Project Name: **AMENDMENT re entrance design;  
Bangor Savings Bank Bank/Office building with two lane drive-through**  
Project ID: #2015-080  
Address: 20 Marginal Way CBL: 113 A 025001  
Applicant: Bangor Savings Bank  
Planner: Jean Fraser

Project Name: **Bangor Savings Bank Bank/Office building with two lane drive-through**  
Project ID: #2015-080  
Address: 20 Marginal Way CBL: 113 A 025001  
Applicant: Wendy Durrah, Bangor Savings Bank  
Planner: Jean Fraser

Bank/Office Building with Bank Drive-through, 20 Marginal Way  
Level III Conditional Use and (Level II) Site Plan  
Bangor Savings Bank, Applicant  
Project #: 2015-080  
CBL 113 A025001

EXTERIOR ELEVATIONS

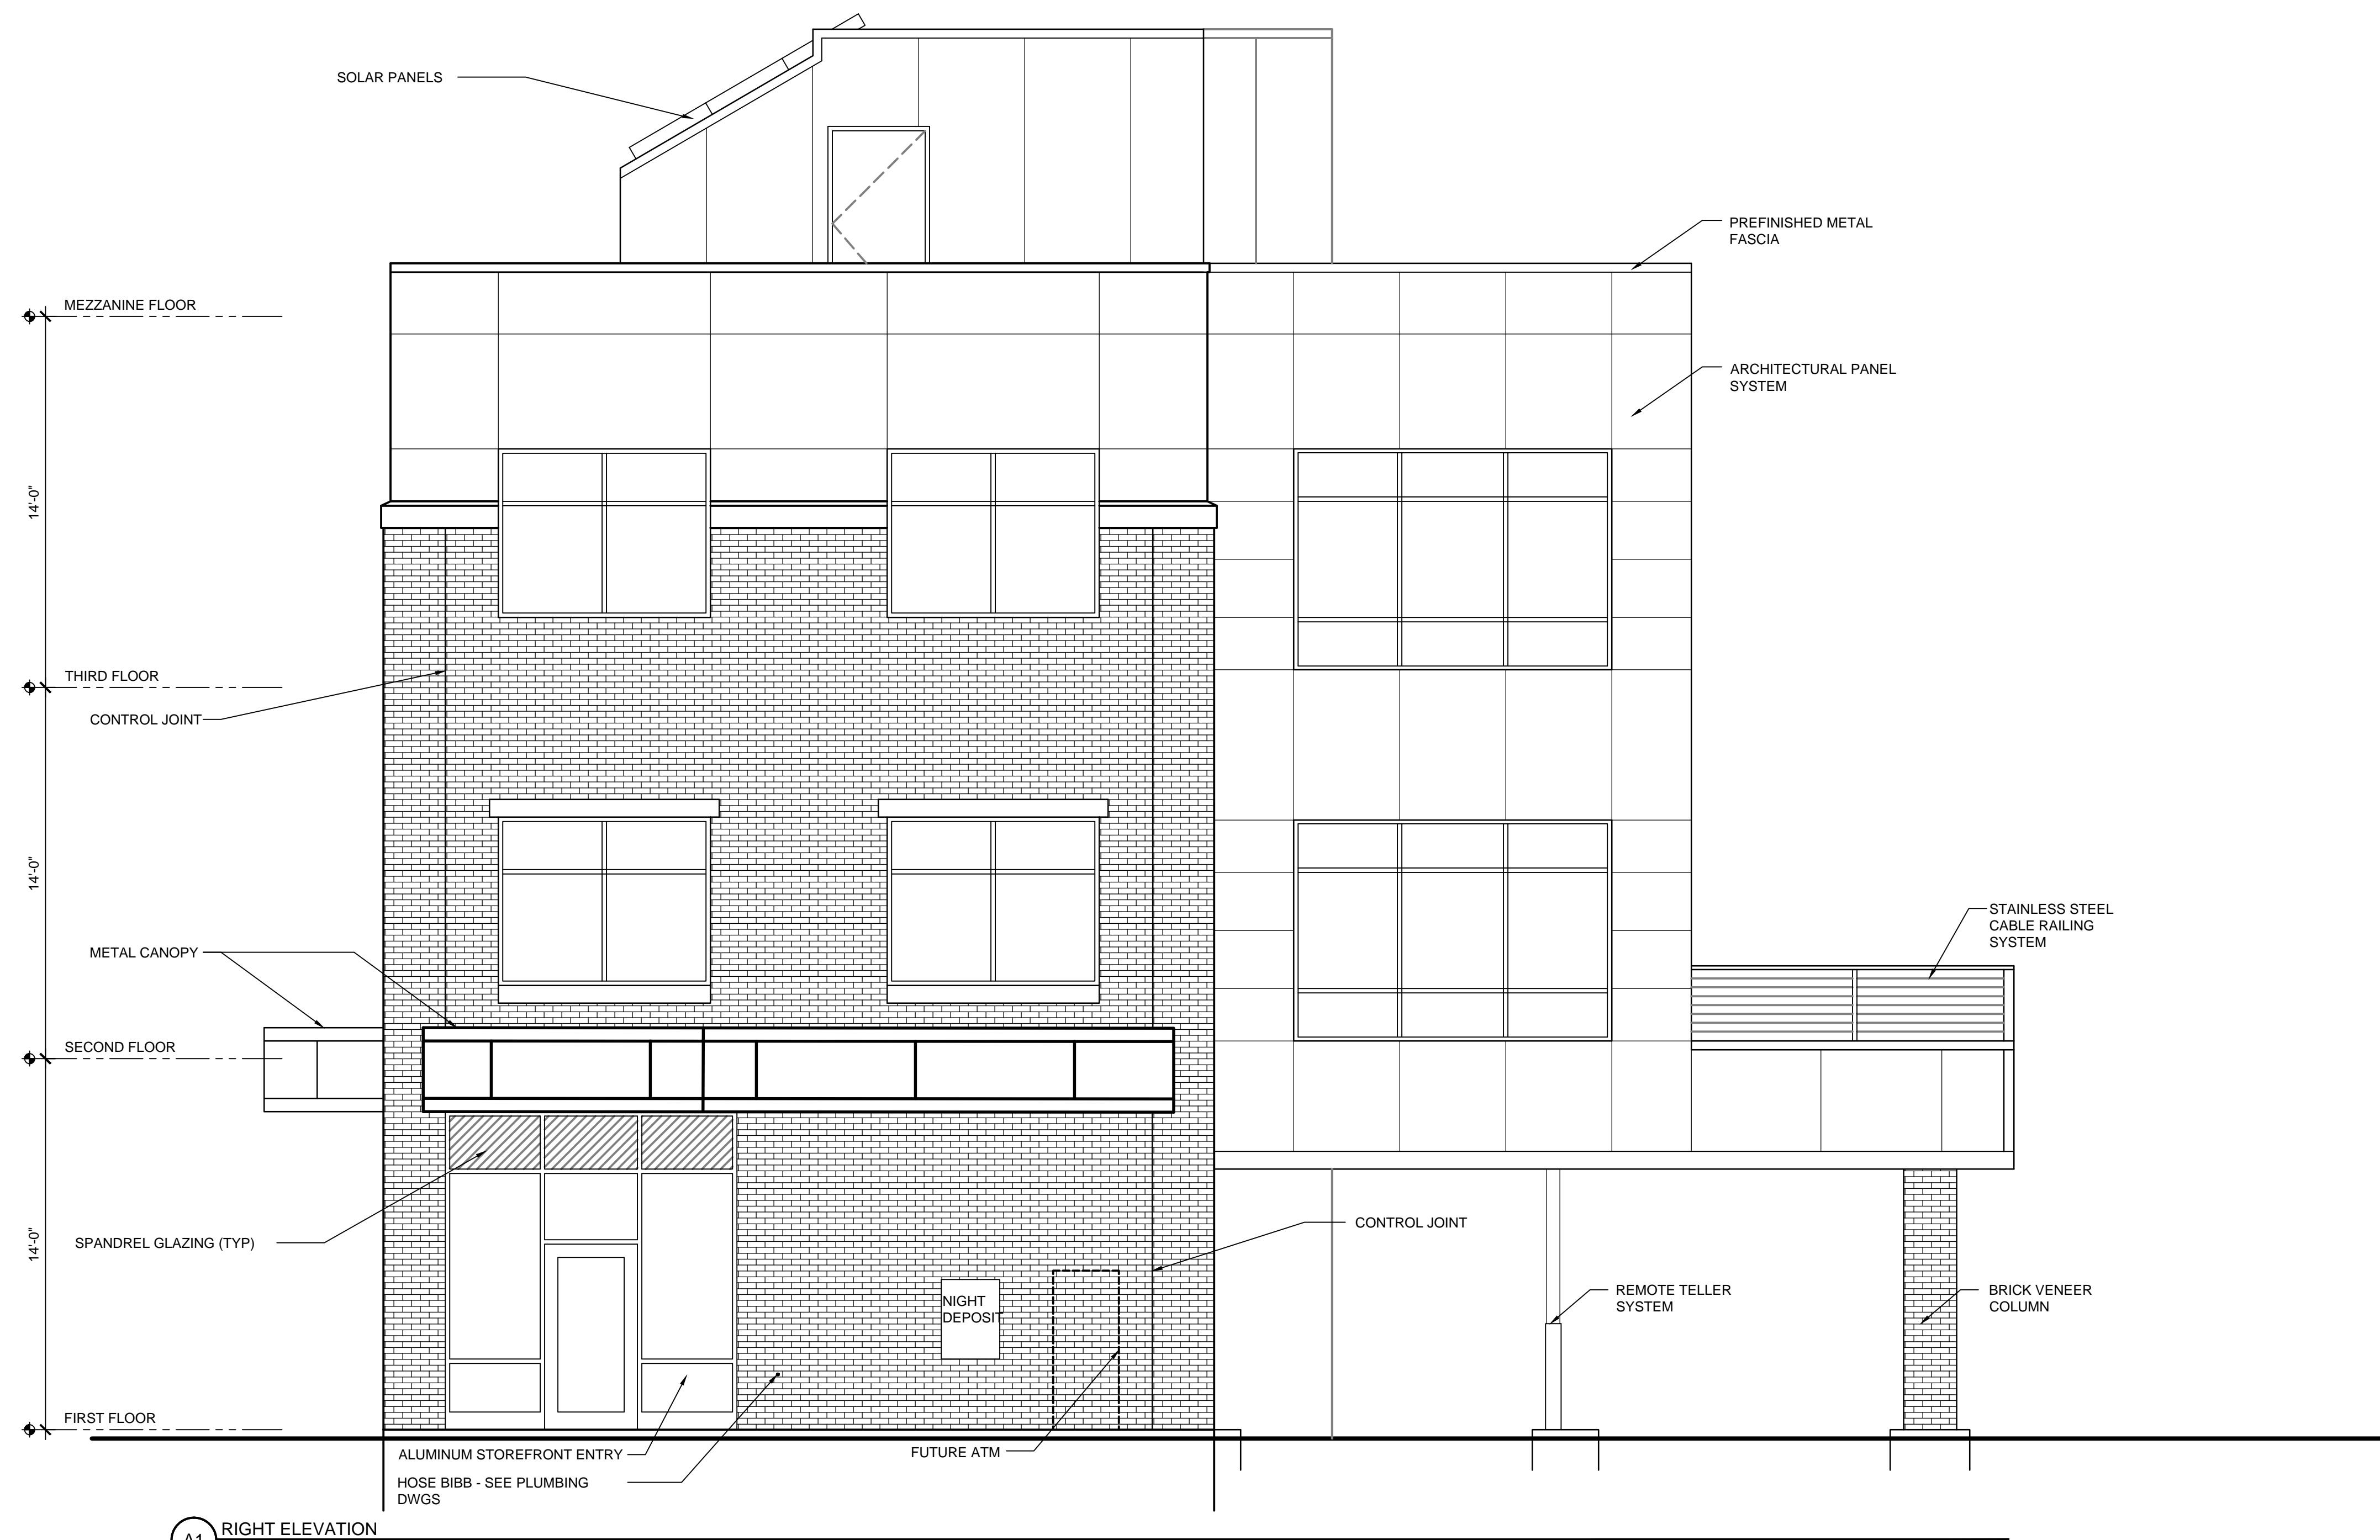
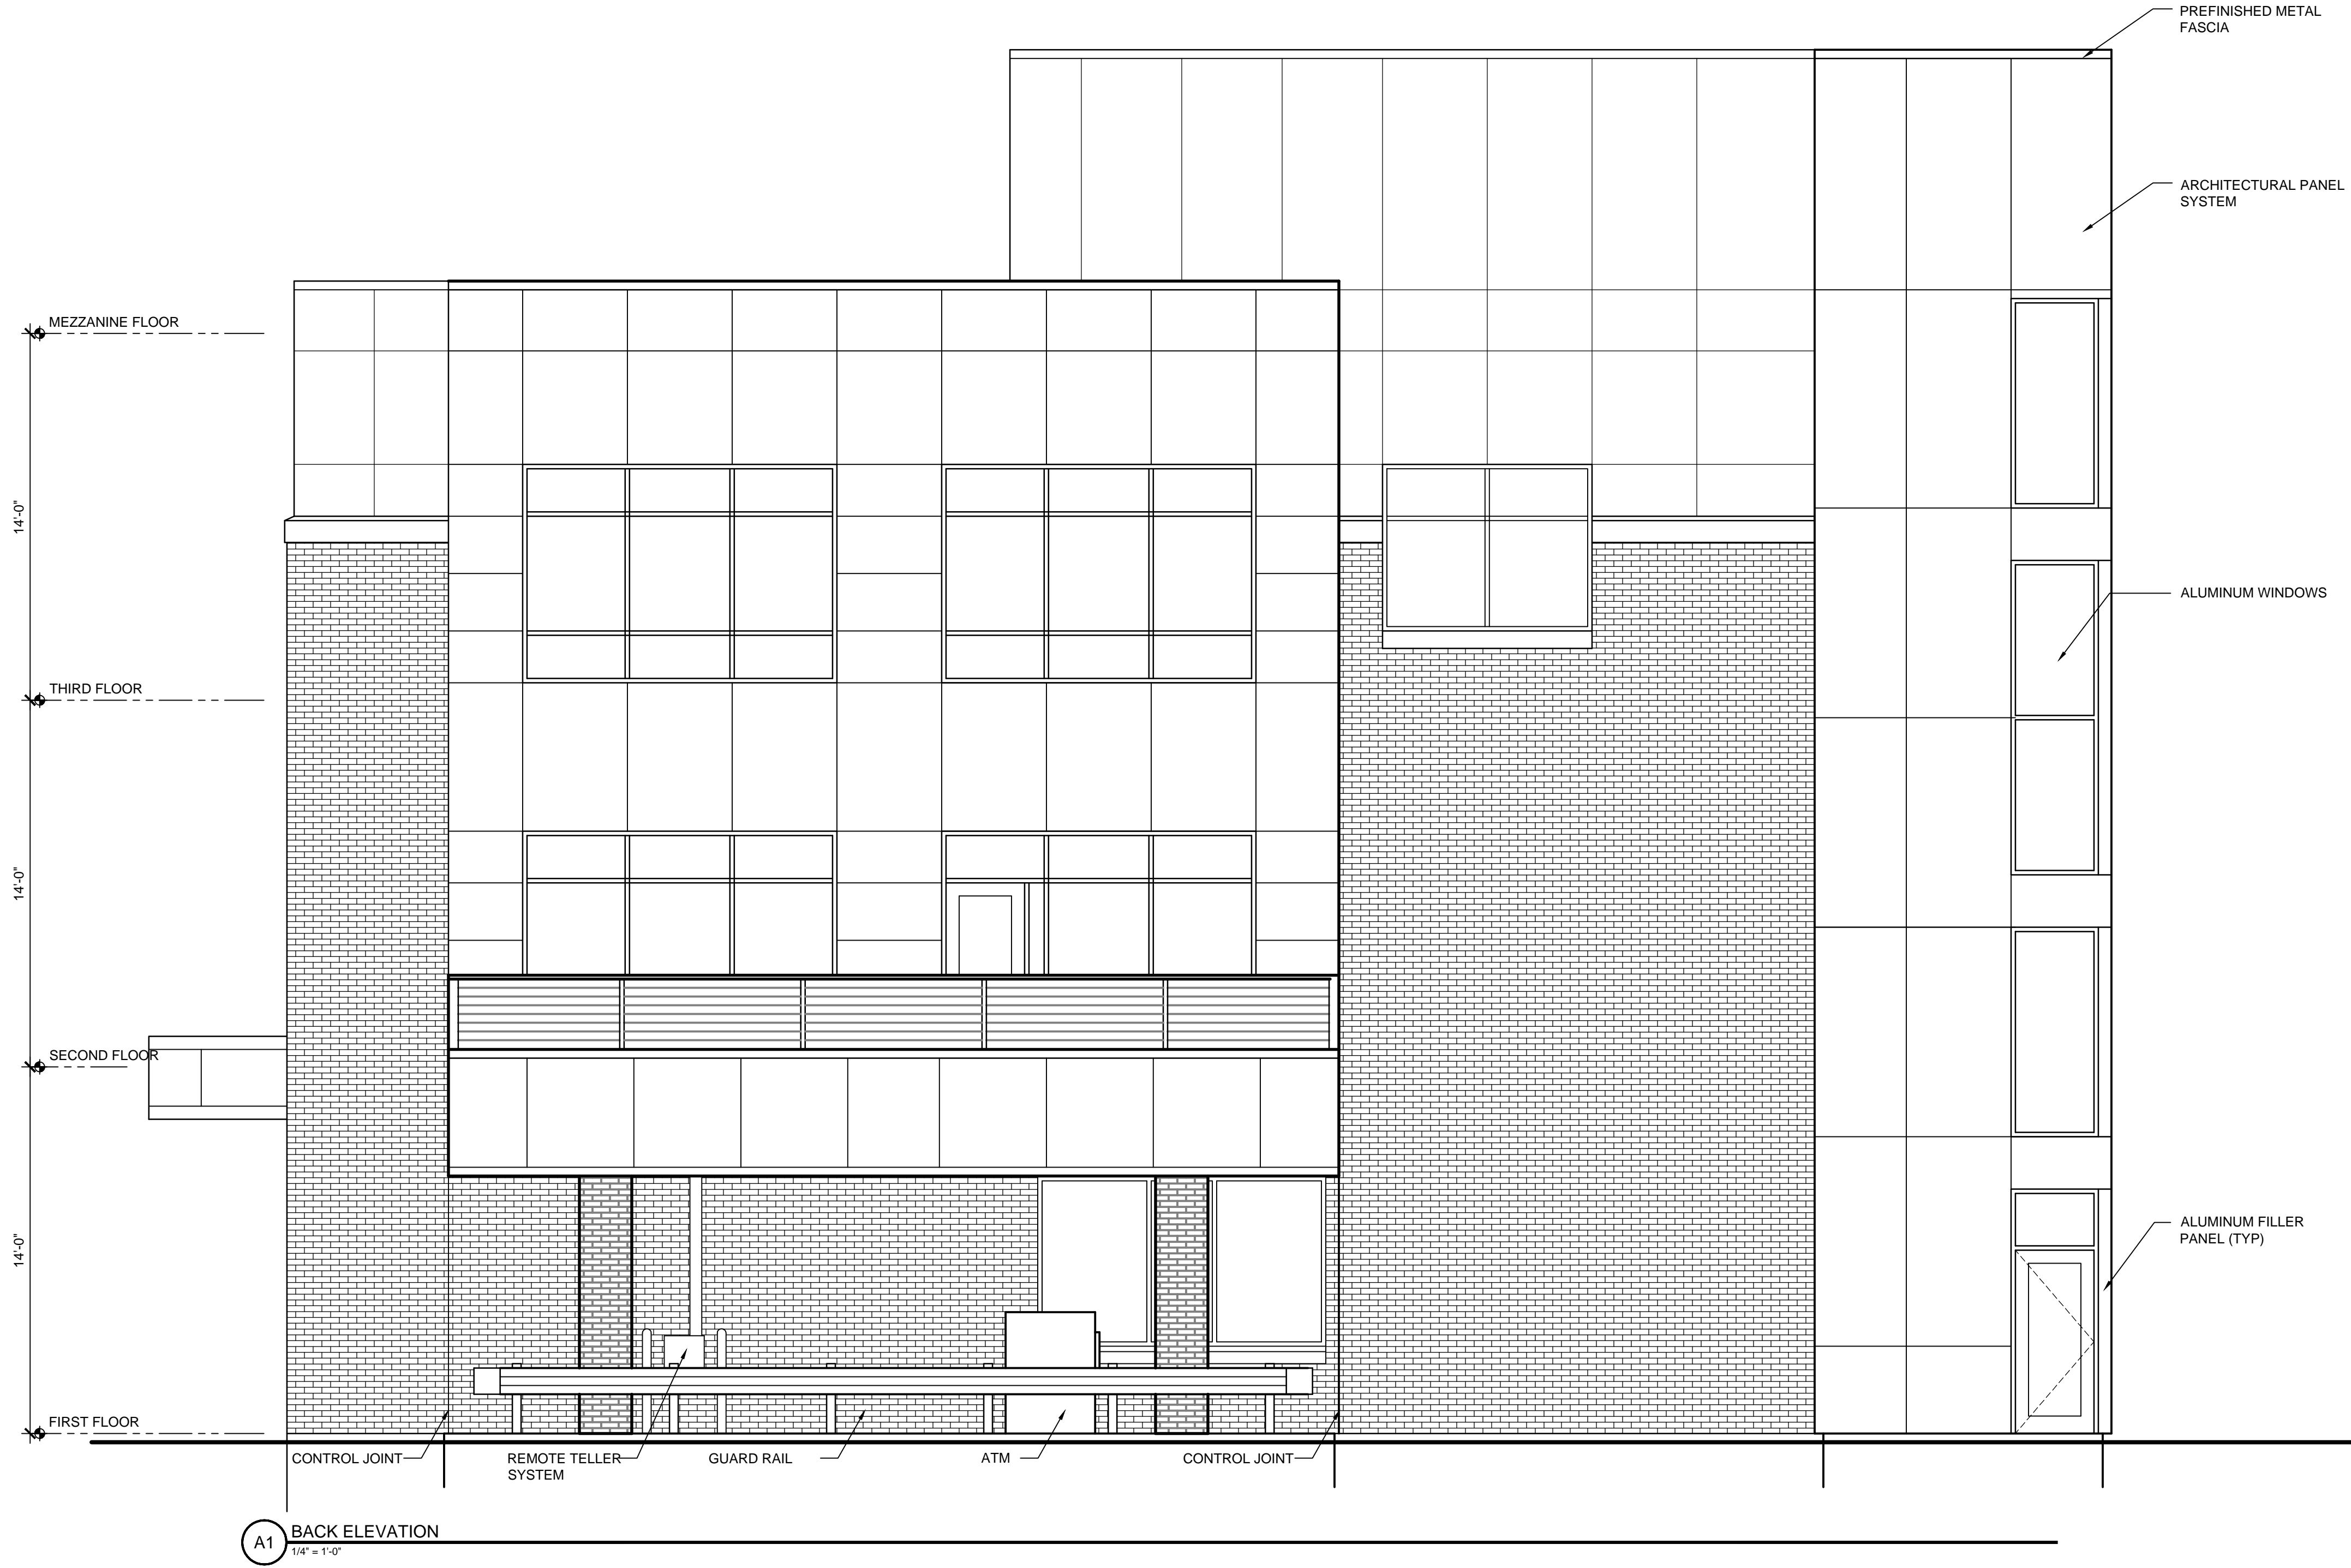
- **Proposed glass has a VLT of .56 which is lower than the allowed .7. A sample is required** before staff can assess whether the transparency is adequate.
- **Spandrel glass (opaque) is proposed** for the upper portion of the ground floor storefront which is **not allowed by the Standard**. See comments below.

- Building elevations remain the same
- Glazing for entire building shall be Solexia + Solarban 60 with a VT of .61 and which has a slight green tint. The lower Visible Transmittance and slight green tint are allowed as a compromise for better energy performance in the building and with the understanding that interior shades will not be used.
- Spandrel glass shall be used on the transom section of storefront on the first floor only (as shown in the elevations) to mask the floor plate behind.
